Date: March 11, 2025

Re: 25-FRM-049
Framing Inspection
Lot 33 Cotton Farms
264 Deer Tail Lane
Fuquay-Varina, NC 27526
Permit No.: SFD2407-0008

At your request, a site visit was made to the above referenced single family residence under construction to inspect two framing concerns noted by the inspector.

2ND FLOOR FRAMING PLAN
WALLS AND CEILING: 1/4" = 1'-0"

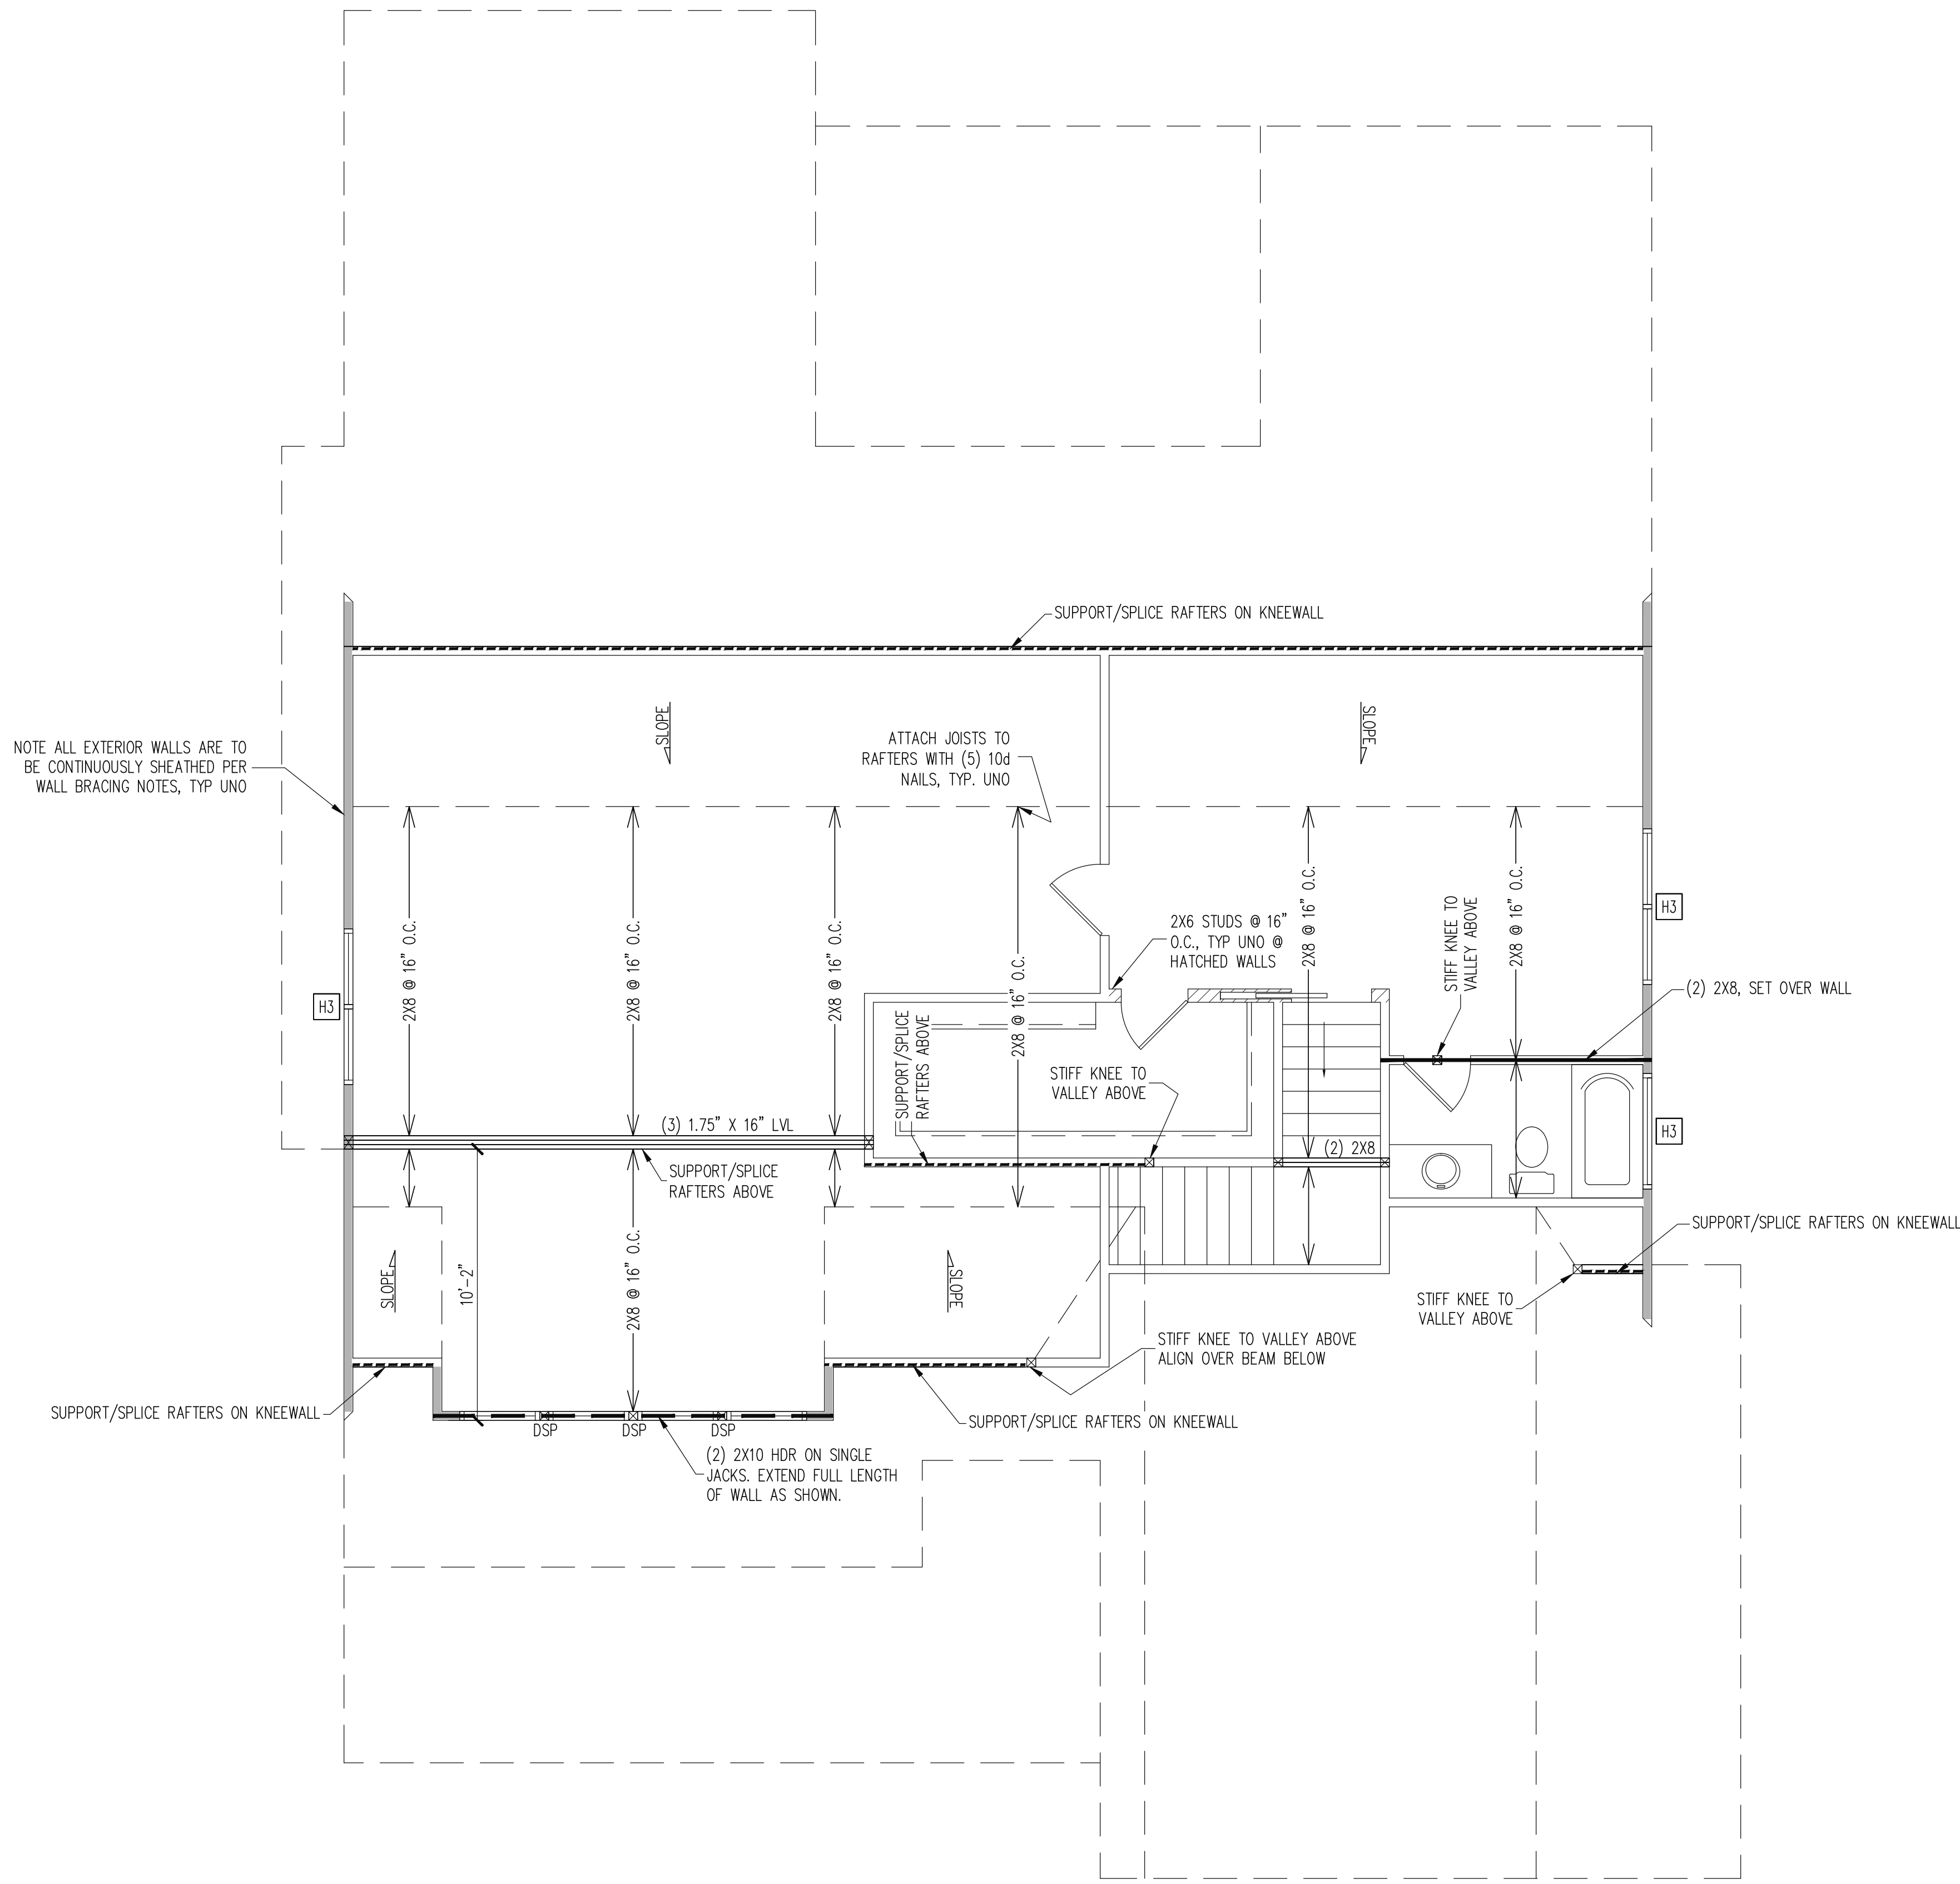
1. A small section of the ridge above the dining room was damaged at the bottom and top edges.
2. The front end of the (2) 1 $\frac{3}{4}$ "x16" LVL beam above the left front bathroom was measured to have 3 $\frac{1}{2}$ " of bearing on the perpendicular wall in lieu of extending over the parallel wall to have 6" of bearing per plan.

1. Cut back the rafters on one side and reinforce the ridge with a 2x10x4'-0" scab centered on the damage. Fasten the scab to the ridge with (3) rows of 10d nails spaced 12" o.c.
2. Fasten a 1 $\frac{3}{4}$ "x9 $\frac{1}{4}$ "x4'-0" LVL scab to the right side of the noted (2) 1 $\frac{3}{4}$ "x16" LVL beam with (2) rows of 5" long Simpson Strong-Tie SDS (or equivalent) screws spaced 12" o.c. The LVL scab is to have 3 $\frac{1}{2}$ " bearing on the double top plates. Additionally, fasten a flat 2x6 stud to the rear side of the (4) 2x4 stud column with (2) rows of 10d nails spaced 6" o.c. The (3) LVL plies are to bear directly on the flat stud. Furr out the remainder of the front bathroom wall to conceal the flat stud.
